**FINAL DRAINAGE REPORT  
FOR  
SOLACE APARTMENTS**

**November 25, 2020  
Project No. 25174.00**

PCD File No. PPR-20-047

EXISTING DRAINAGE MAP  
SOLACE AT CIMARRON HILLS  
JOB NO. 25174.00  
3/12/21  
SHEET 1 OF 1

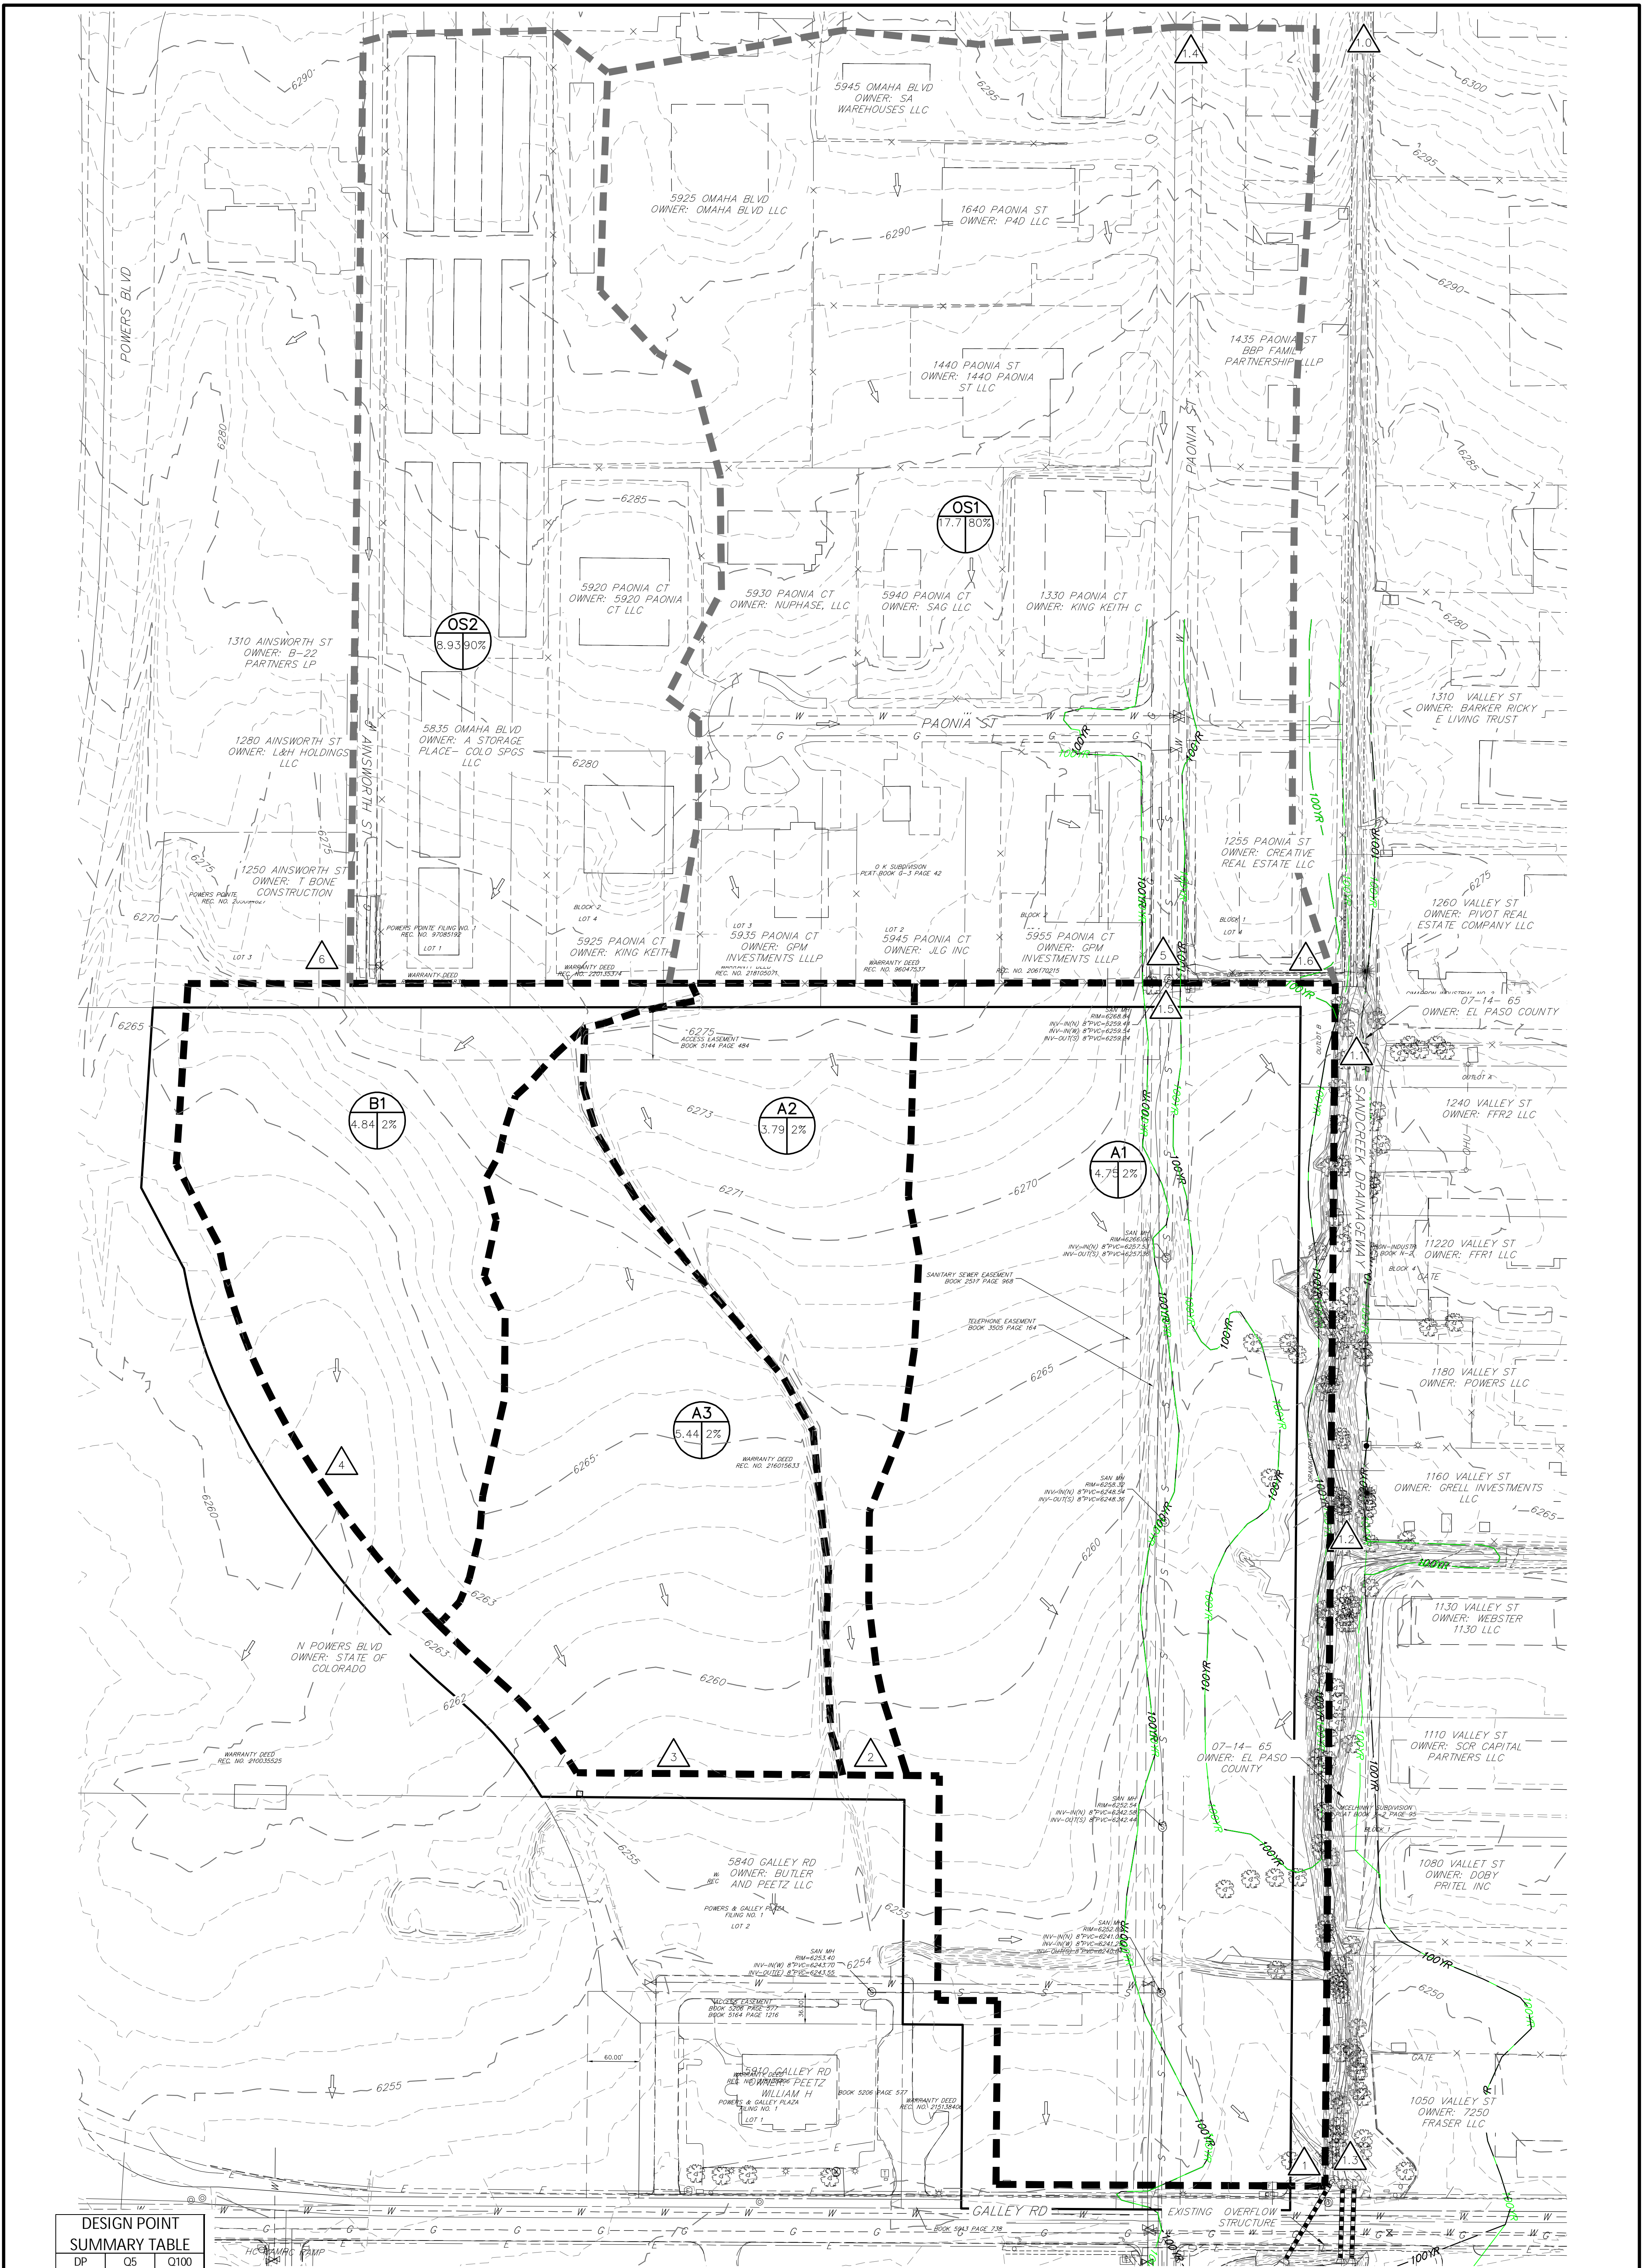
DP43 per proposed drainage plan and DP 5 per the existing drainage map. Revise accordingly

DP44 in proposed map and DP 6 in existing drainage map. Revise accordingly.

The table on the drainage map indicates 862 cfs. Revise accordingly.

Please clarify in the narrative that DP 1.0-1.3 are on the existing drainage map and 5.0-5.3 are in the proposed drainage map.

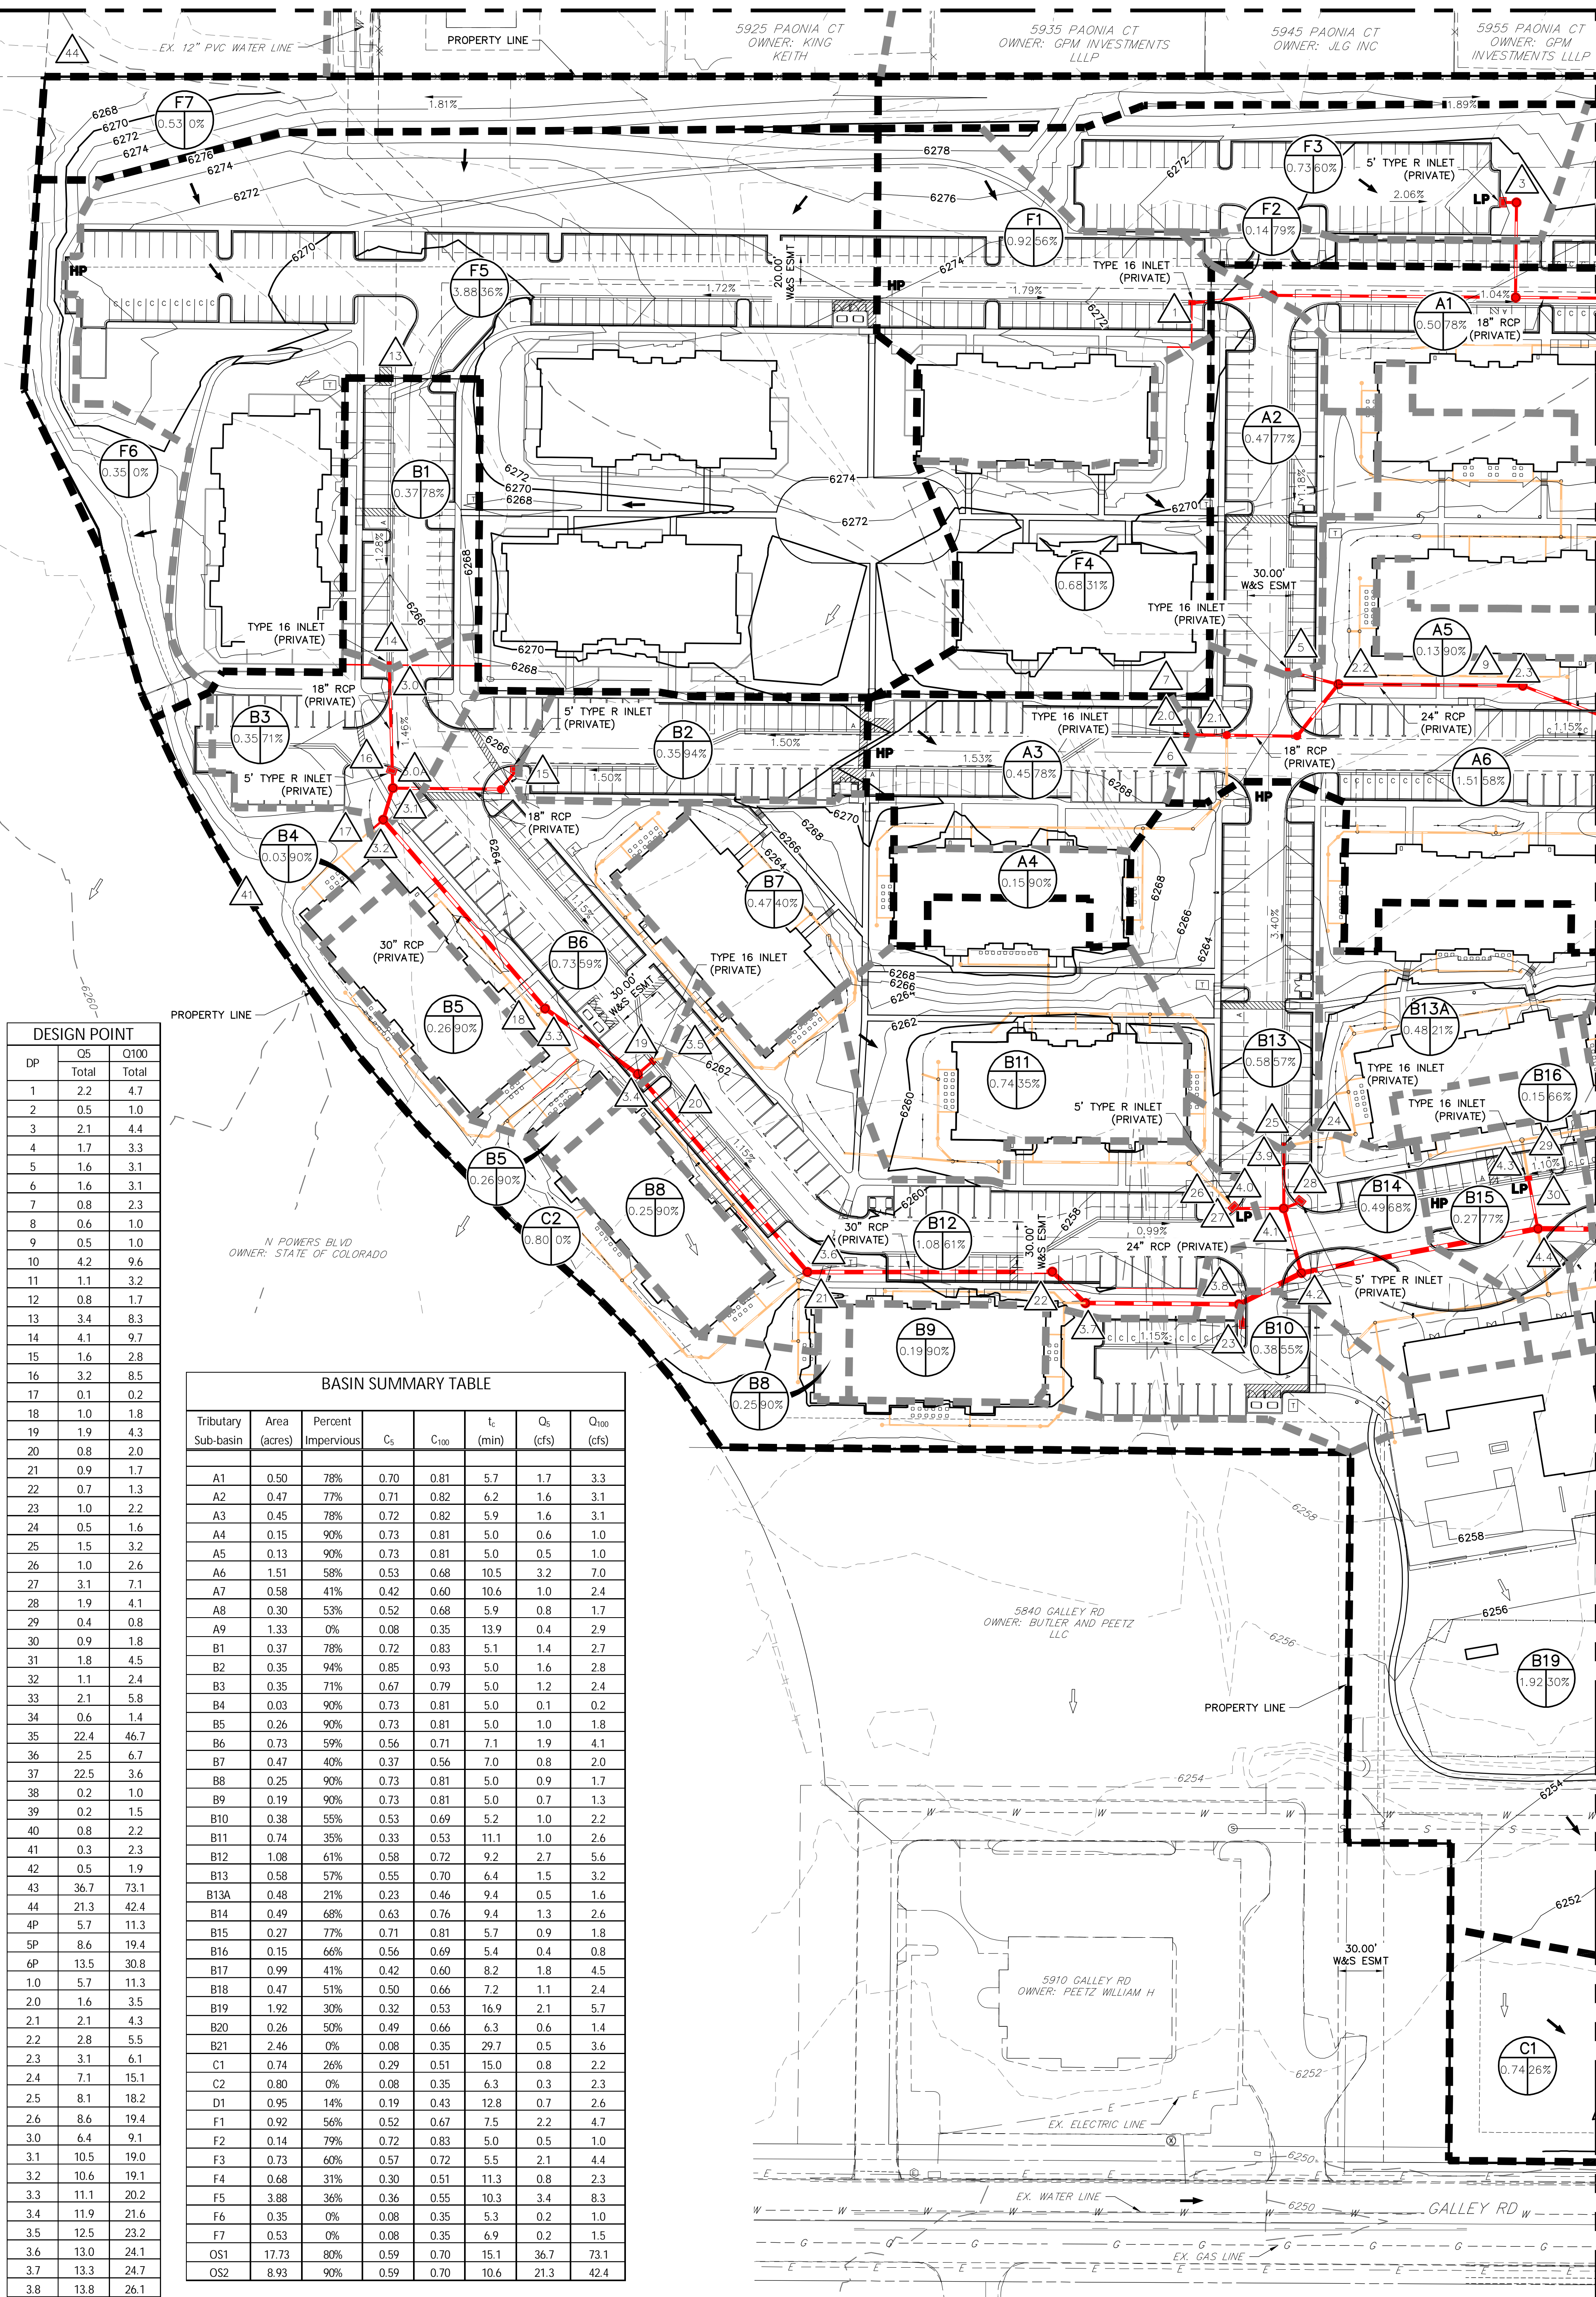
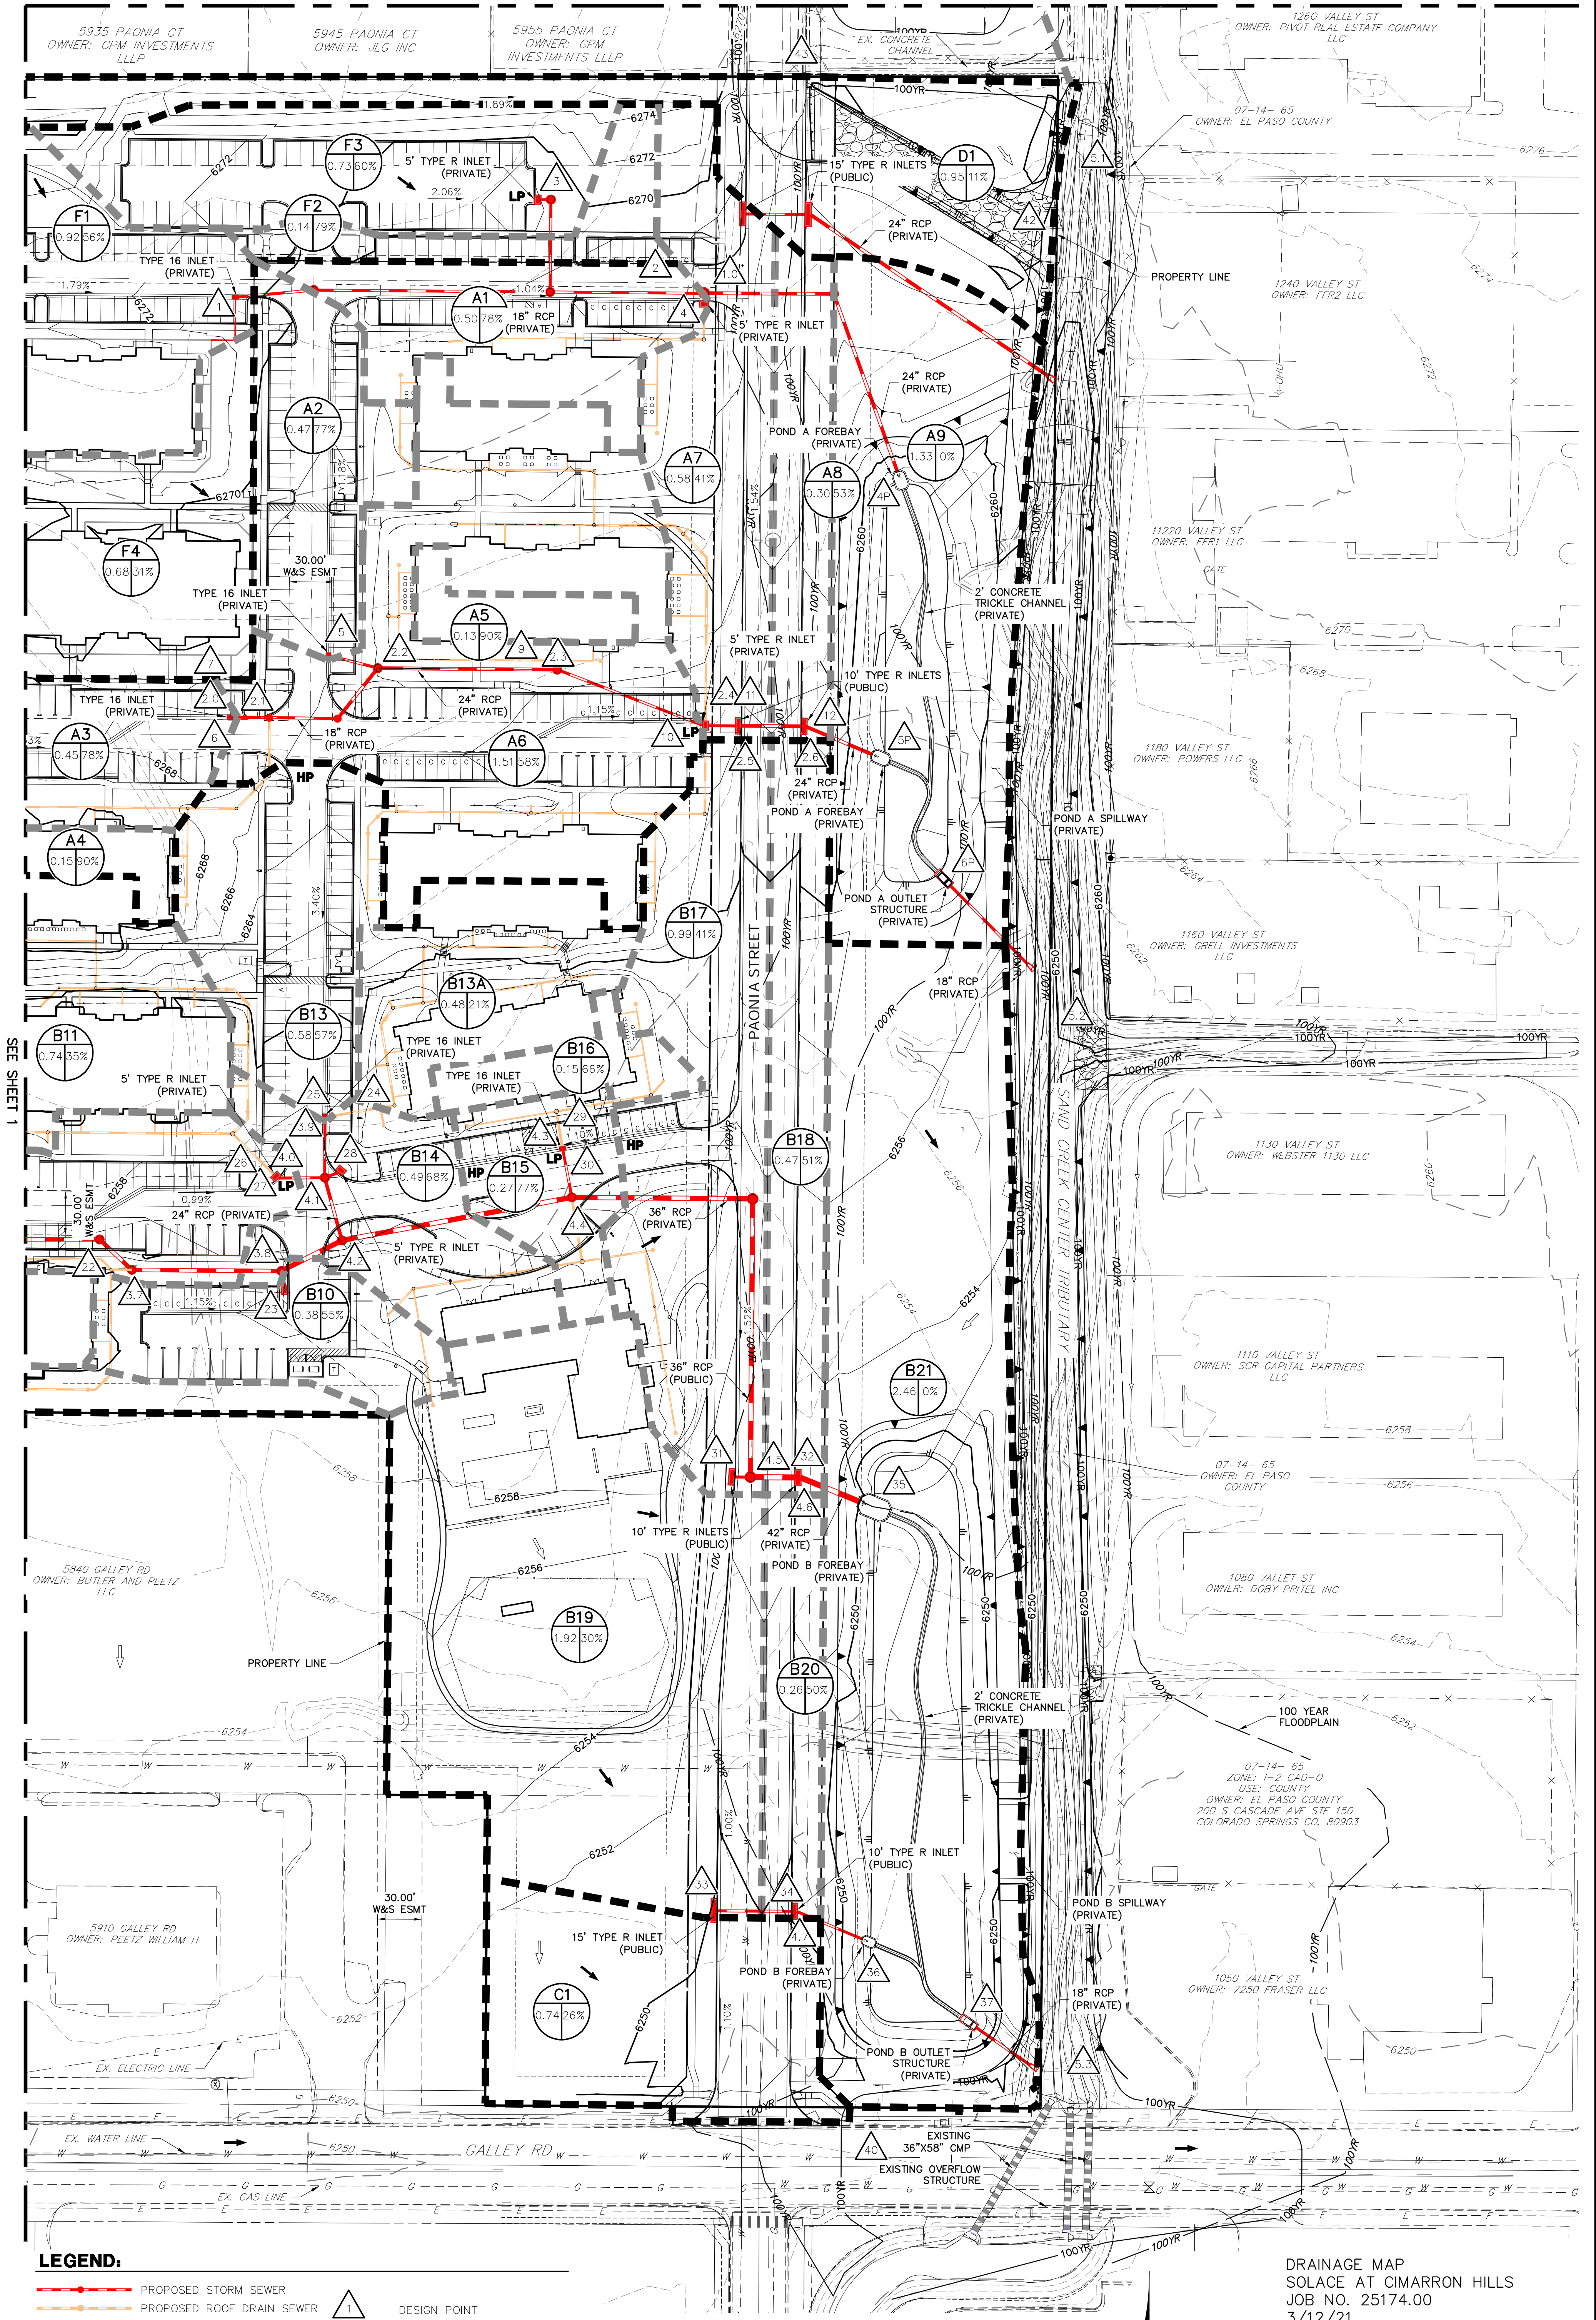
Please revise your description as the drainage map indicates 41% impervious. If this is correct then the basin wouldn't be primarily paving.

0.37 is indicated in the drainage map. Revise accordingly so that they match.

0.35 is indicated in the drainage map. Revise accordingly so that they match.

DP41 was not found on the drainage plan. pLease provide

Please show this DP on the plan
